Your Ref: OWPC4903
Our Ref: EP/175/14/PL 27-11-2014
Please ask for:
Mrs A Gardner

Change of use of retail (A1 Shops) to business (B1 Business) including new shop front.
113 Sea Road East Preston

Proposed Shop Front, Scale 1:20

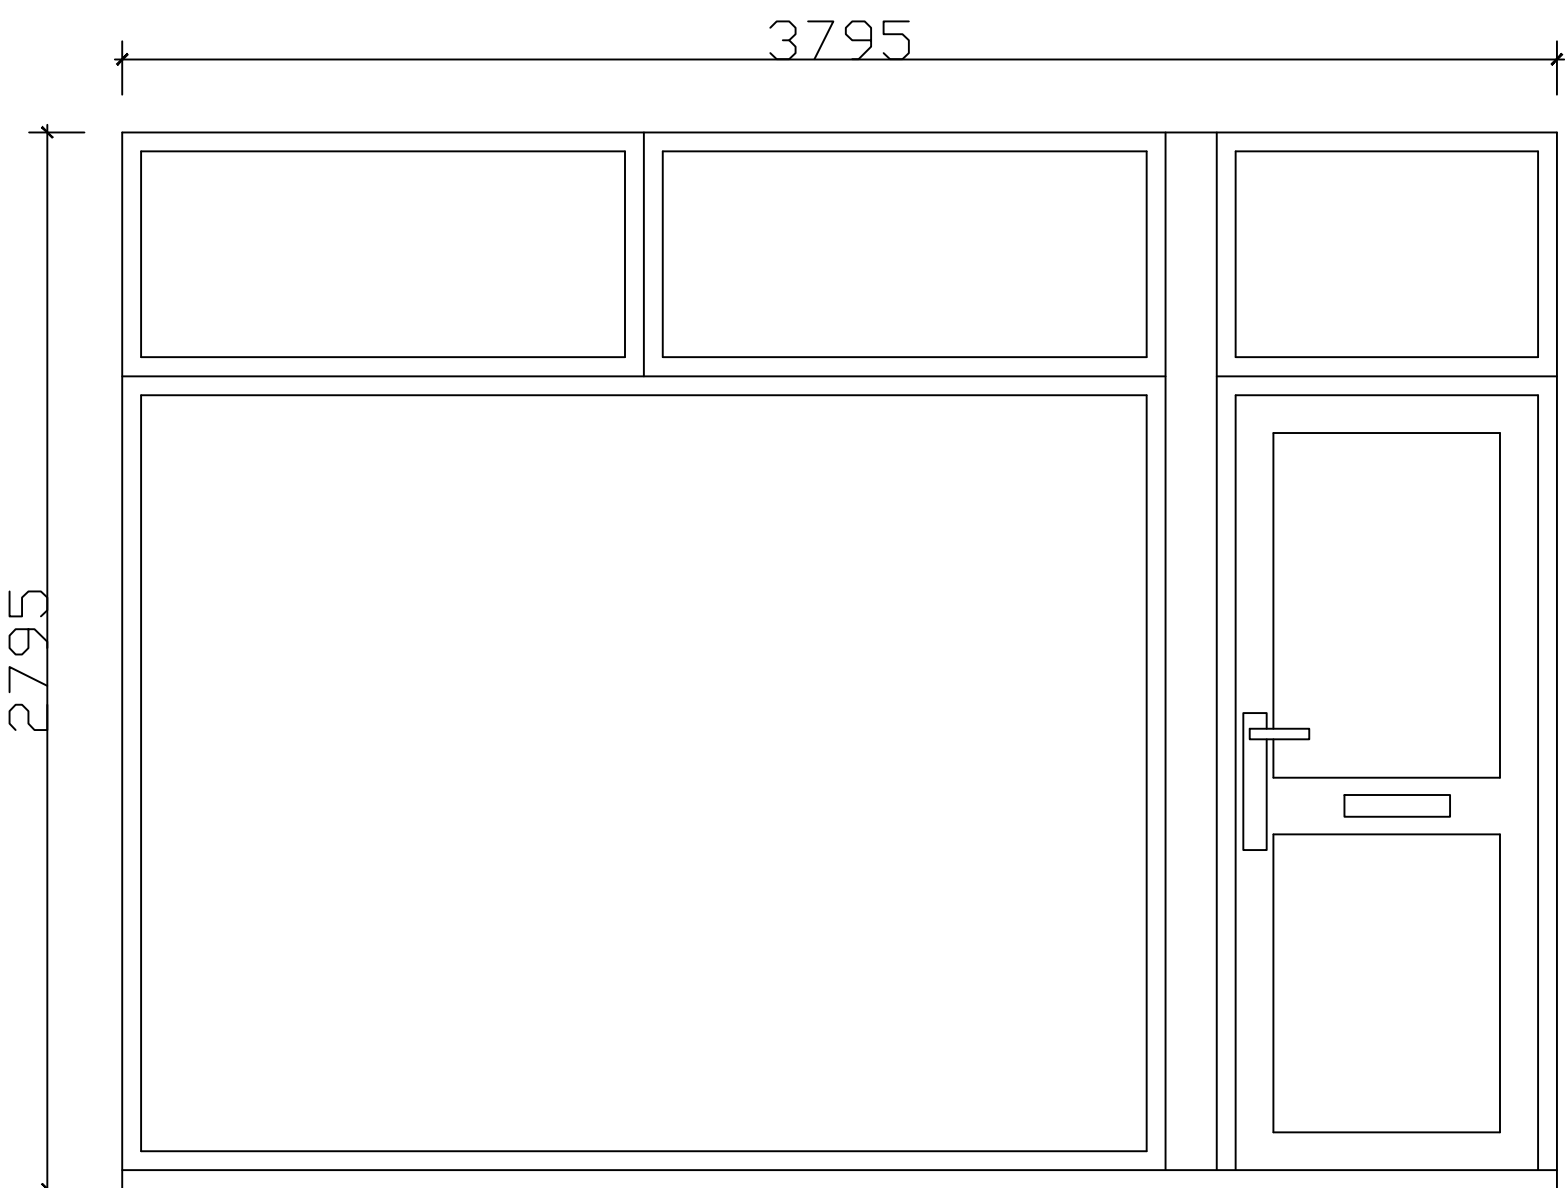
The Society considers the proposed alterations to the shopfront are undesirable and should not be permitted. Parade Mansions has been proposed as an addition to Arun's Local List of Buildings of Character in the East Preston Neighbourhood Plan. This Plan was approved by residents in a referendum on January 28th. The building can be regarded, therefore, as a non-designated heritage asset, and the effect of the application on the significance of the building should be taken into account in determining the application (Para. 135 NPPF). The proposed change to the shopfront would adversely affect the appearance of the building, because it would be out of character with the other shopfronts.

The change should not therefore be permitted. It seems unnecessary, in any case, to alter the shopfront when converting the shop to other uses; the entrance could remain in the centre of the frontage and could lead directly into the waiting room.
